KIRKLEES METROPOLITAN COUNCIL INVESTMENT & REGENERATION SERVICE

DELEGATED DECISION TO DETERMINE PLANNING APPLICATIONS

Reference No:	2026/62/90930/E
Site Address:	349, Whitehall Road, Wyke, BD12 9DP
Description:	Demolition of existing garage and erection of single storey side and two storey side and rear extensions
Recommending Officer:	Jennifer Booth

OFFICER REPORT

Rev - : DD-MM-YYYY : Initial - Issue.  
Drawing Number 26-007 - P - 02

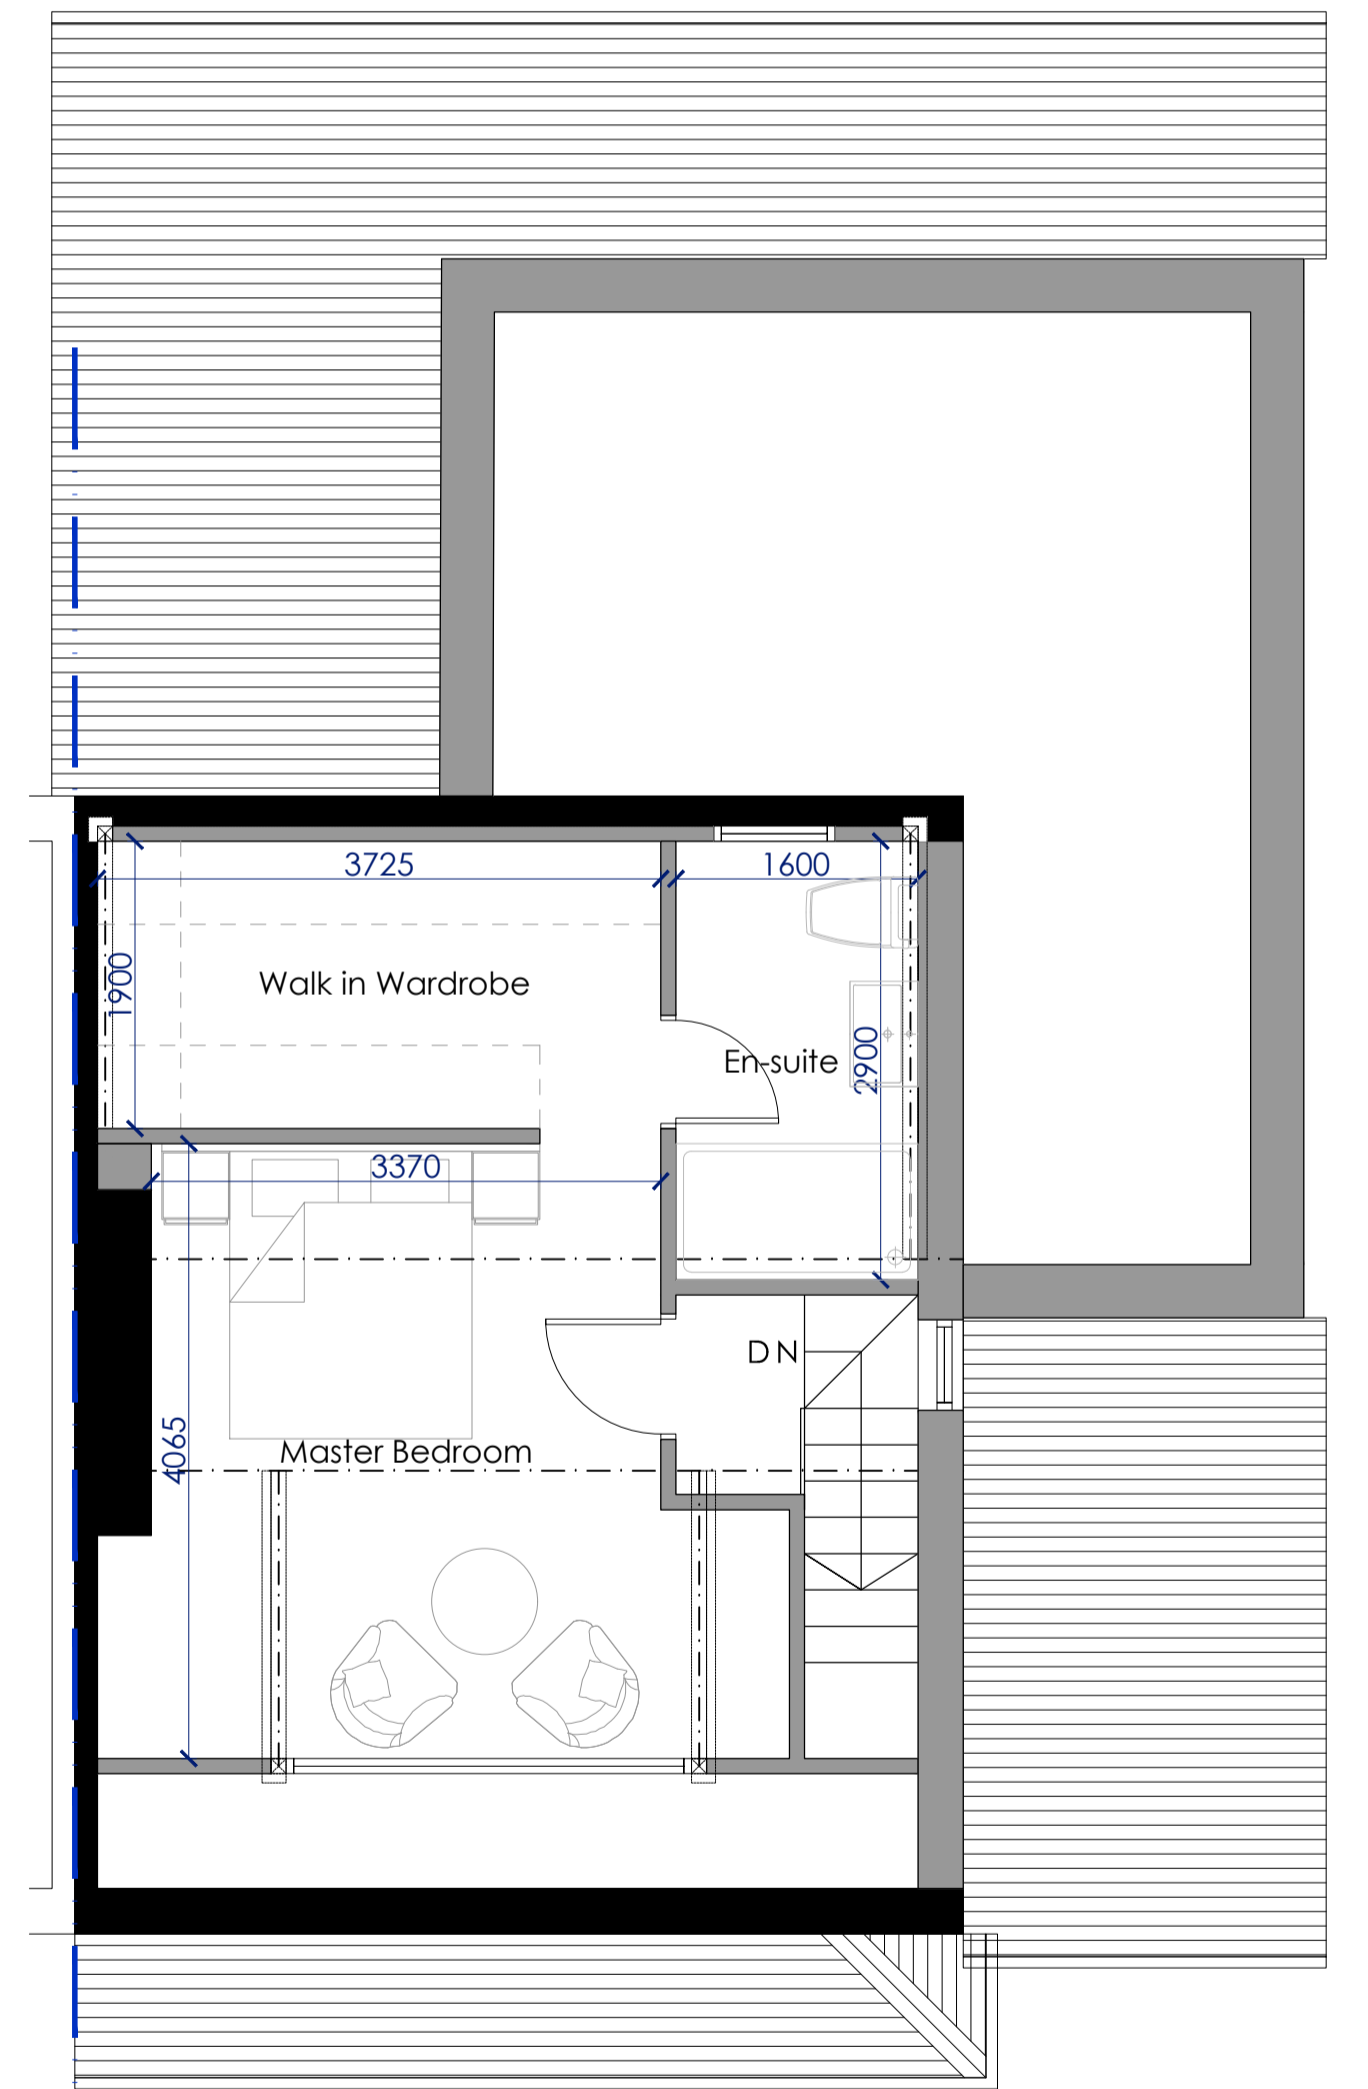
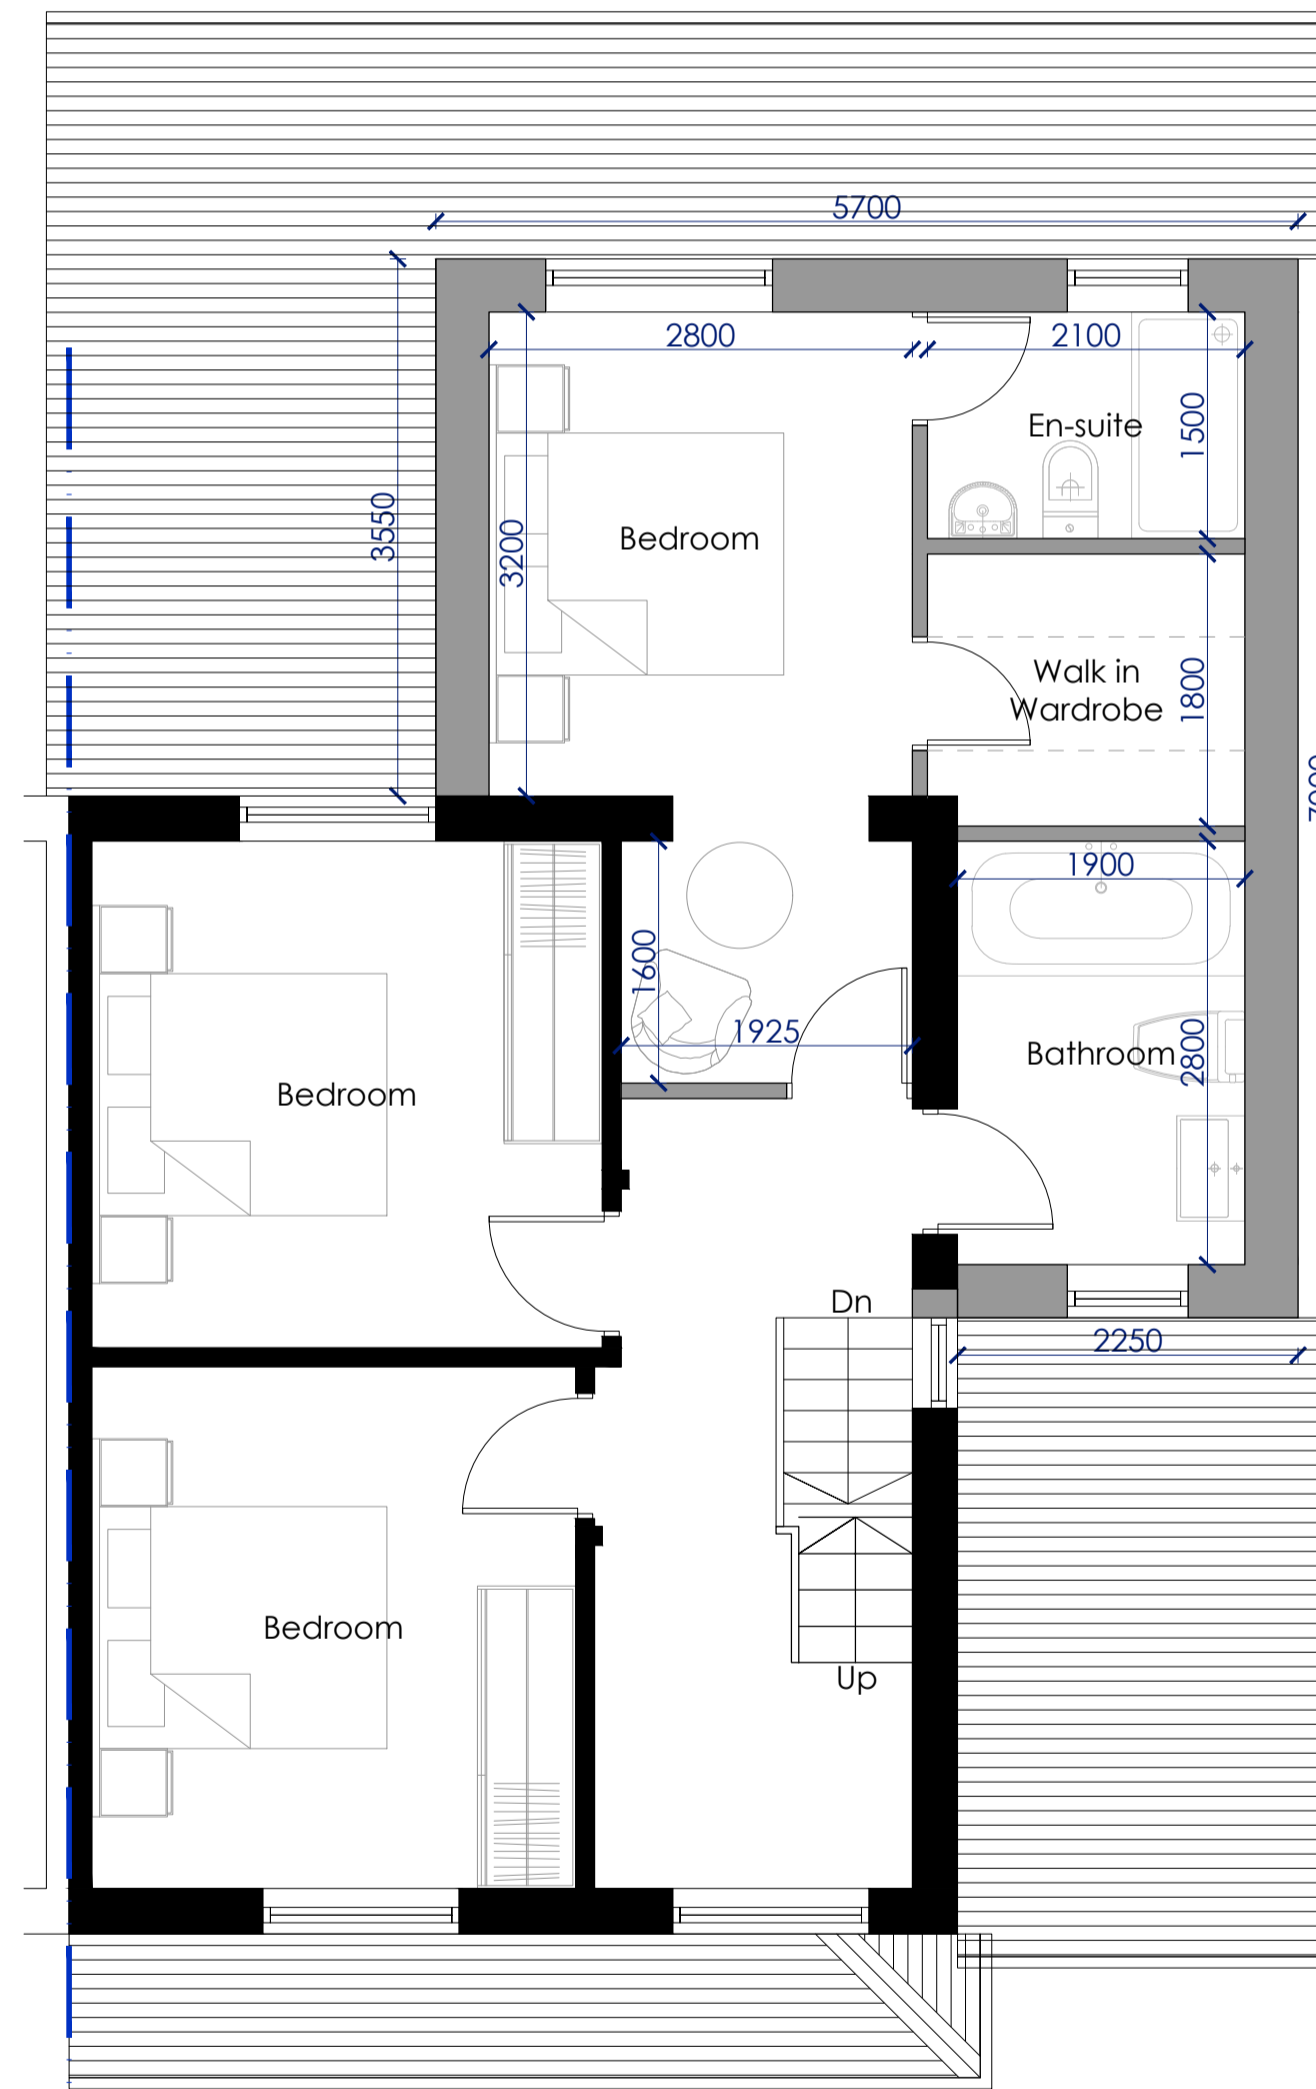
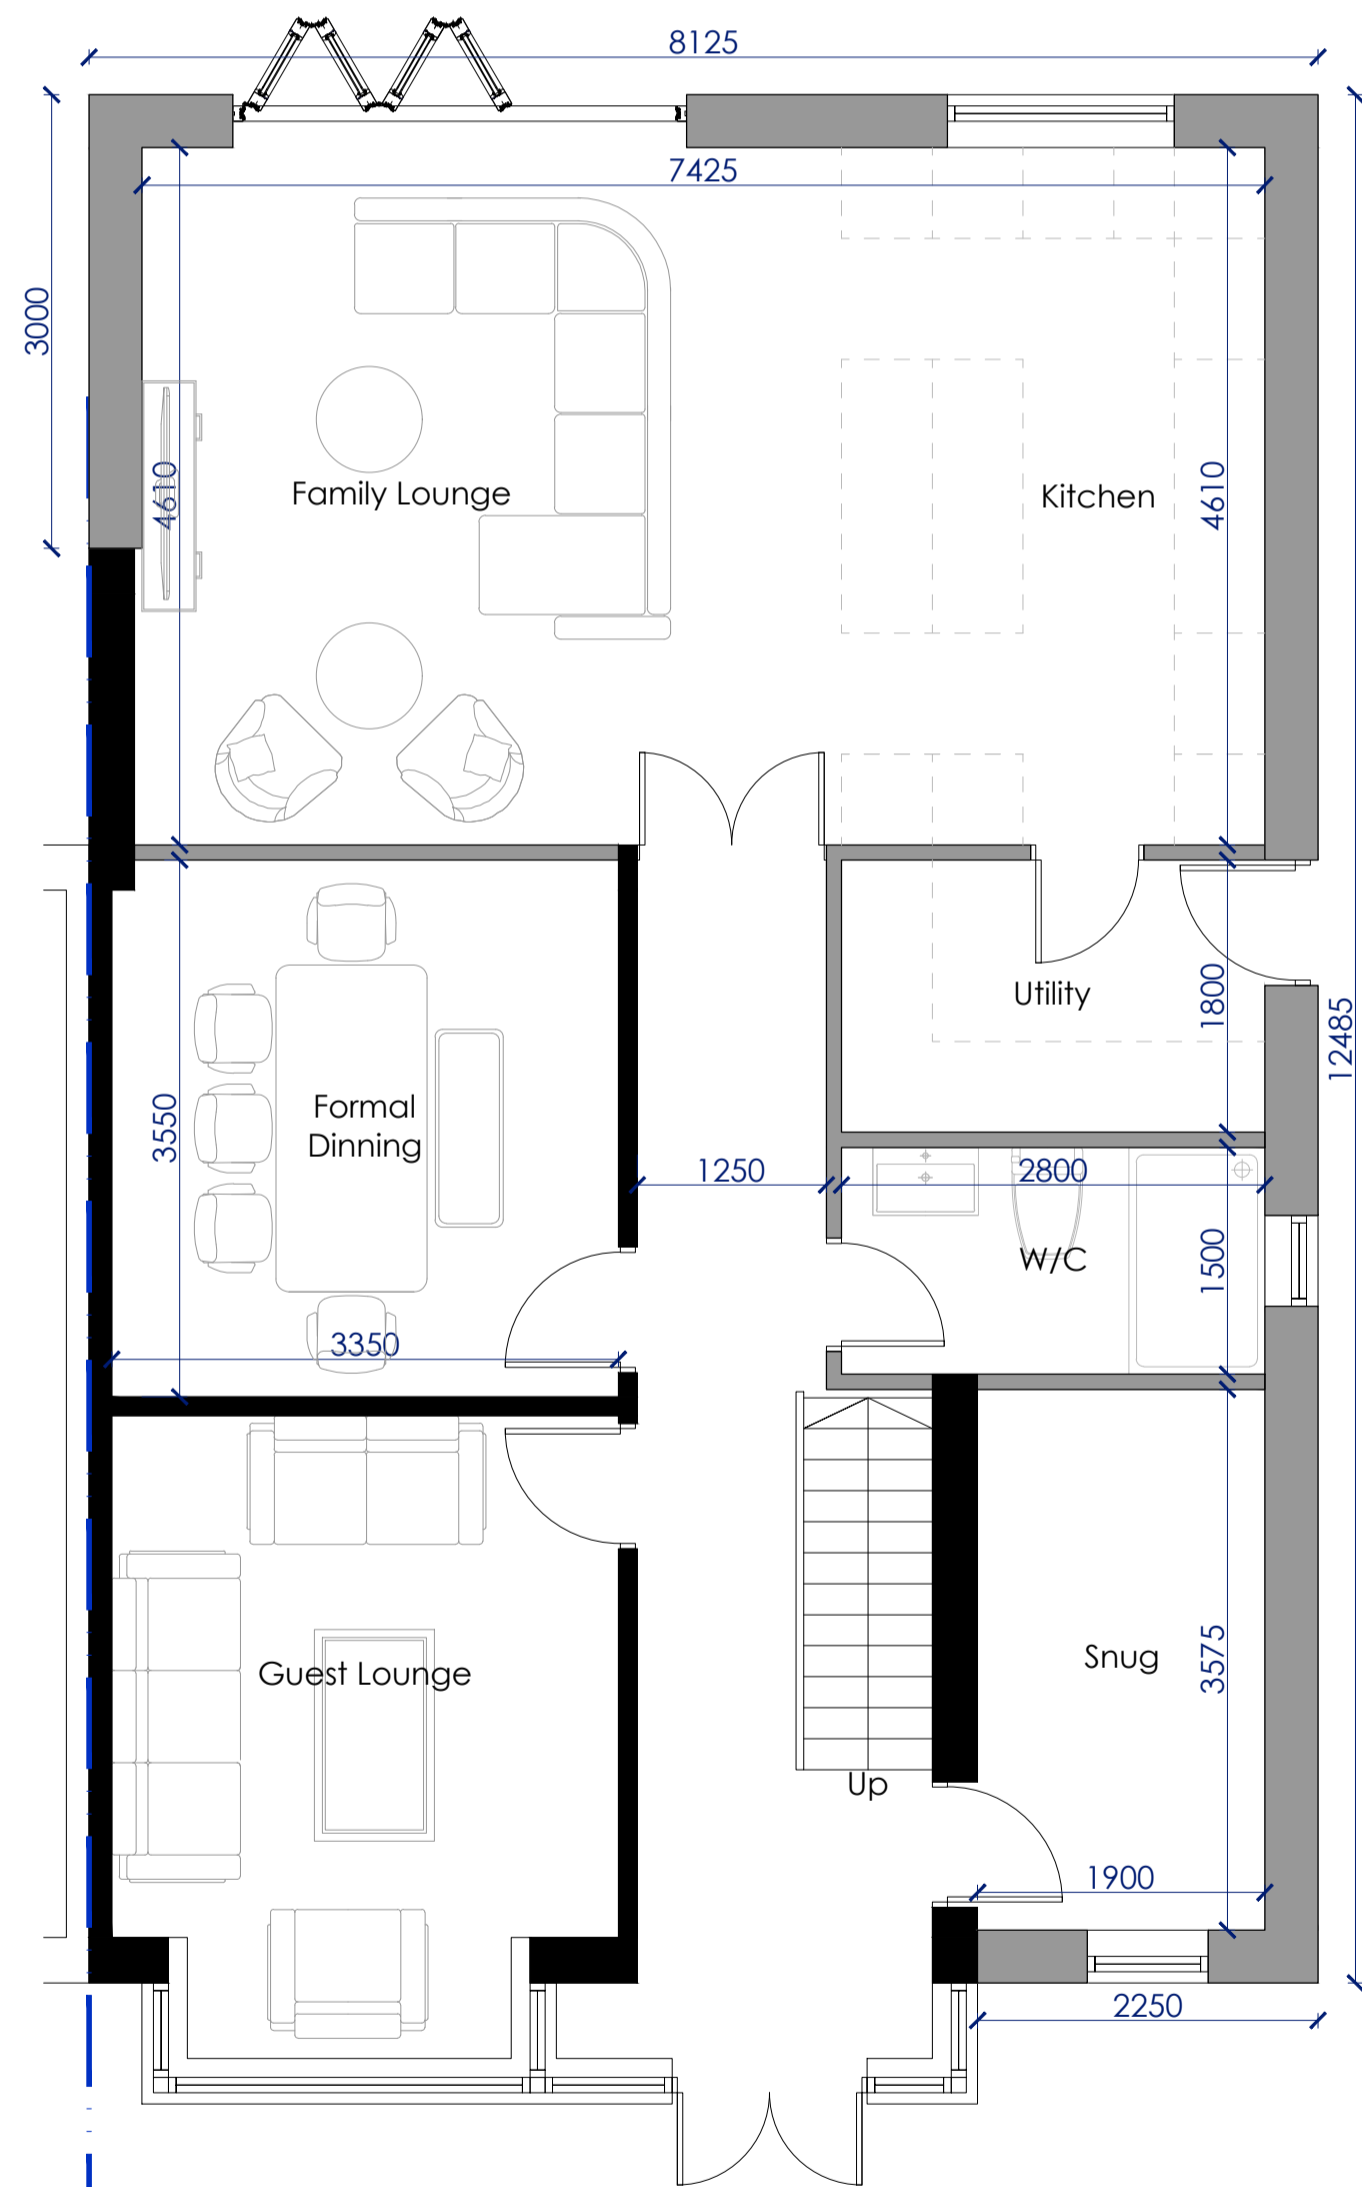
The side extension would project 2.2m from the original size wall, extending the depth of the dwelling on the ground floor. This would be set back 4m at first floor. The rear extension would project 4.9m on the ground floor, extending the width of the dwelling and to the rear of the side extension. The first floor would be inset 2.5m from the shared boundary with a lesser projection of 3.5m. The roof forms would be hipped, lean to and sliding.
